Final Report of Special Inspections

Project: *Addition and Renovations*
Location: *214 Danforth Street, Portland, ME*
Owner: *Shalom House, Inc.*
Owner's Address: *106 Gilman Street*
Portland, ME 04102

JOB NAME: 214 Danforth Street
JOB NO.: 14005
DATE OF VISIT: Sep 09, 2014
TIME: 1:00 P.M.
WEATHER: 70°, clear
CLIENT: Shalom House
OBSERVERS: David Tetreault, SDC

ST-1a	Drawing	Date 7/11/14	Scale As Noted	Architect	SHIELDS ARCHITECTURE Cumberland, Maine (207) 776-8926	
	FOUNDATION PLAN & SECTION	Project: ADDITION & RENOVATIONS 214 DANFORTH STREET PORTLAND, MAINE

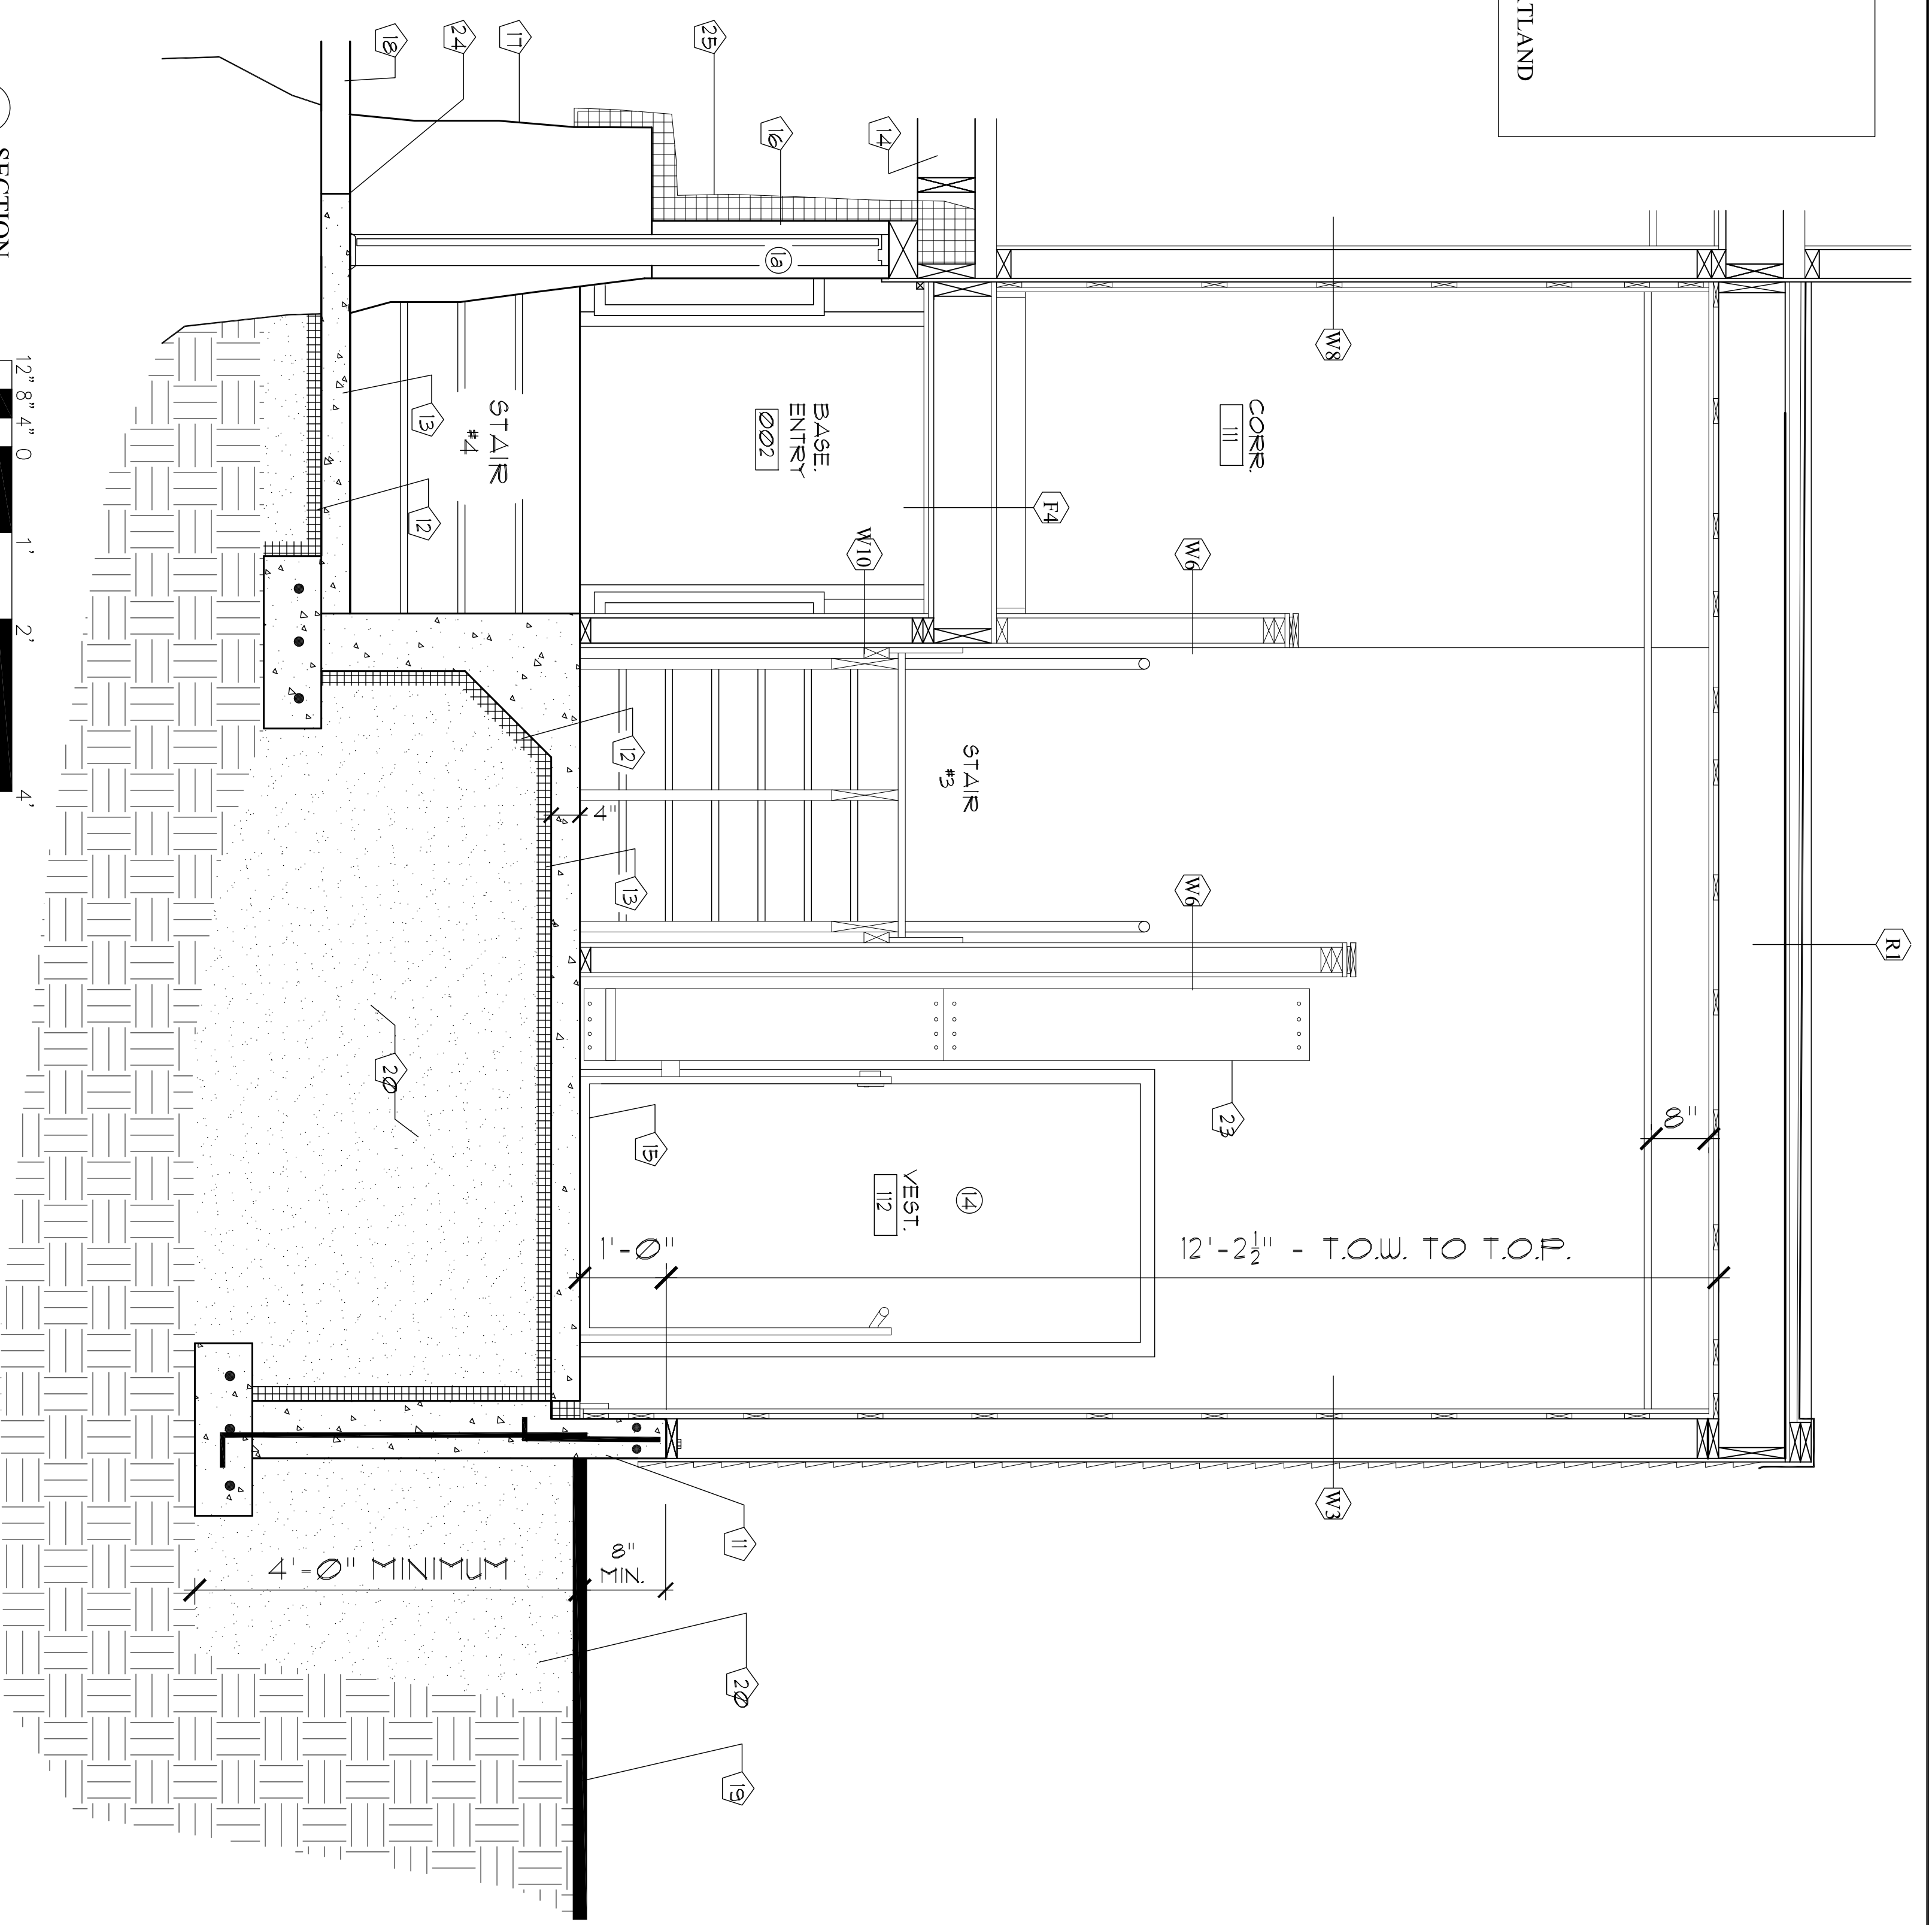
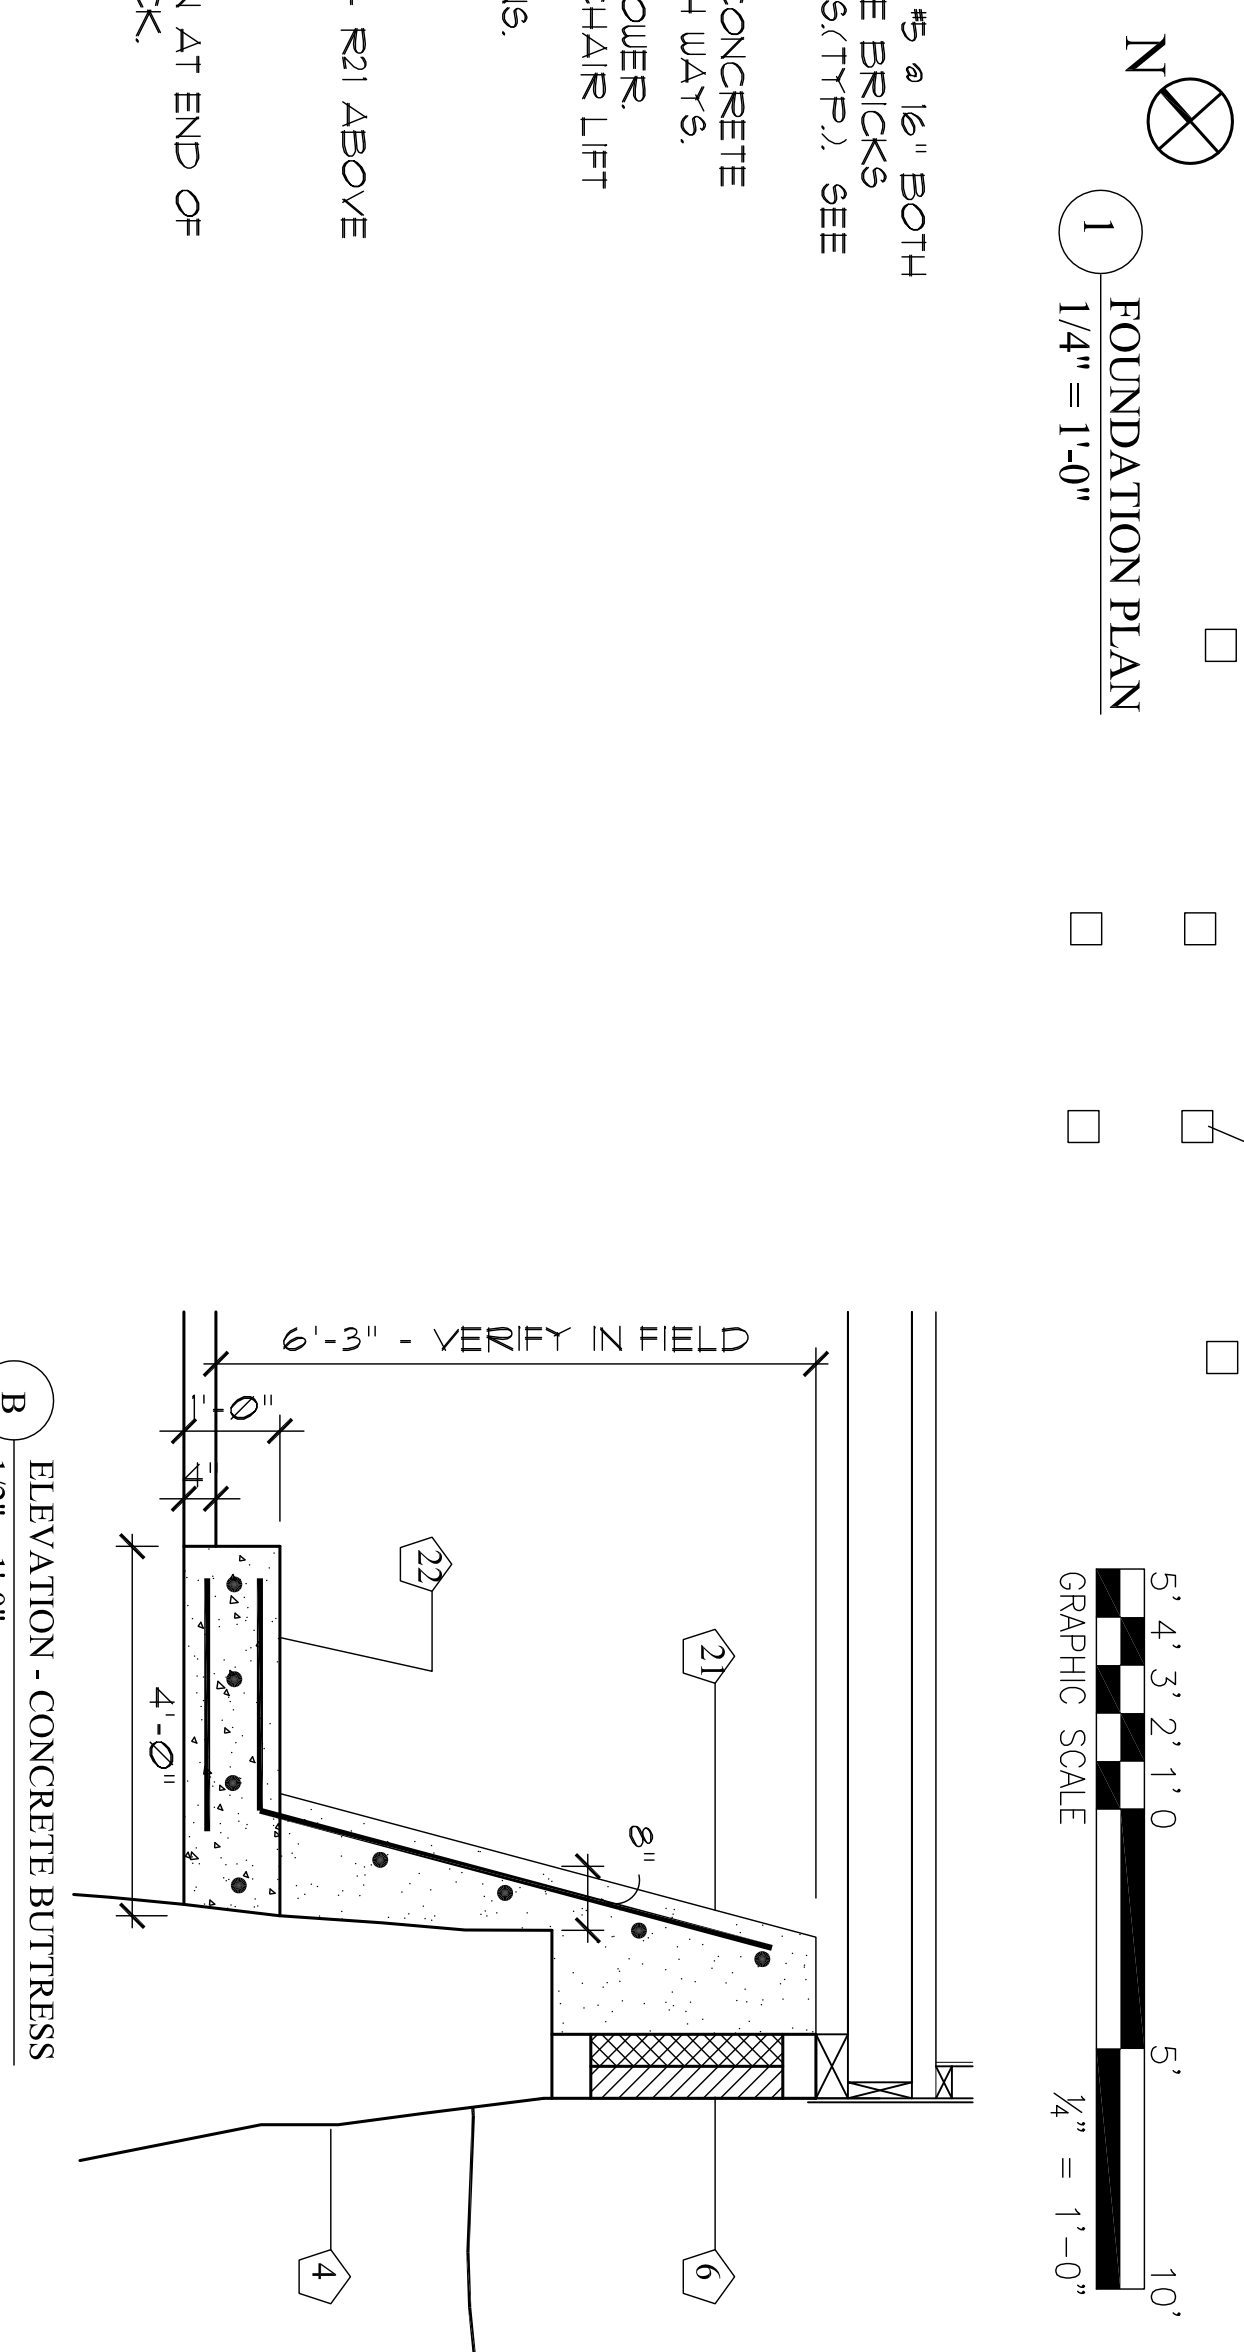
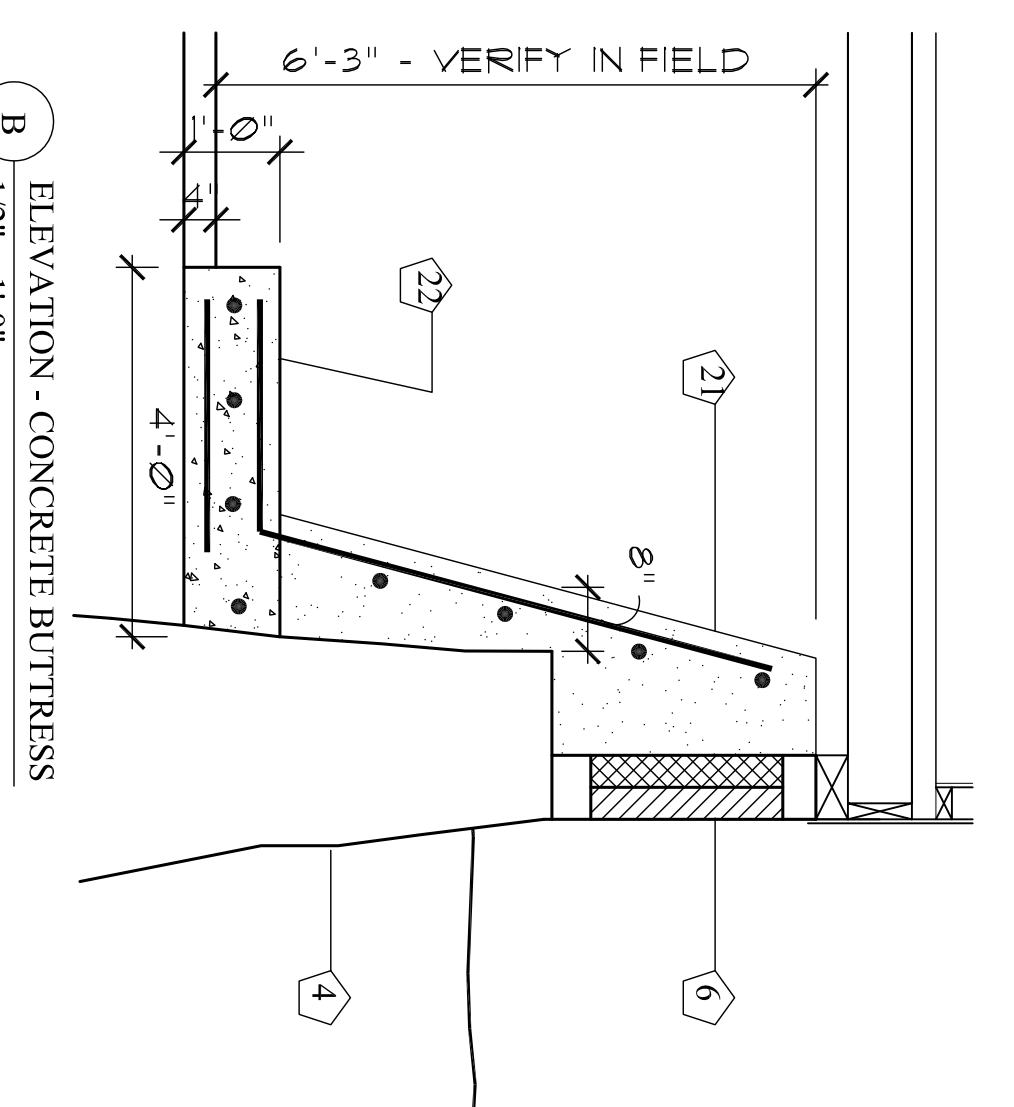
The foundation at the west side has been exposed. Loose bricks and granite pieces must be removed prior to placing concrete for the buttress detailed on sheet ST-1a. A 1st floor beam is supported on the foundation approximately 13 feet south of the rear wall. This beam must be temporarily shored before removing loose brick and granite.

A first floor beam has been found to bear on insufficient corbels at both sides of the chimney at the rear of the building. Steel posts must be added to both sides for support of the beam.

The buttress wall footing has been cast and reinforcing for the buttress wall has been placed.

Framing at the existing building and stair addition are completed.
The foundation wall buttress has been completed.
Additional steel post supports for the beam at the rear chimney have been installed.
Structural work has been found to be in conformance with the Contract Documents.
There is no outstanding structural issue.
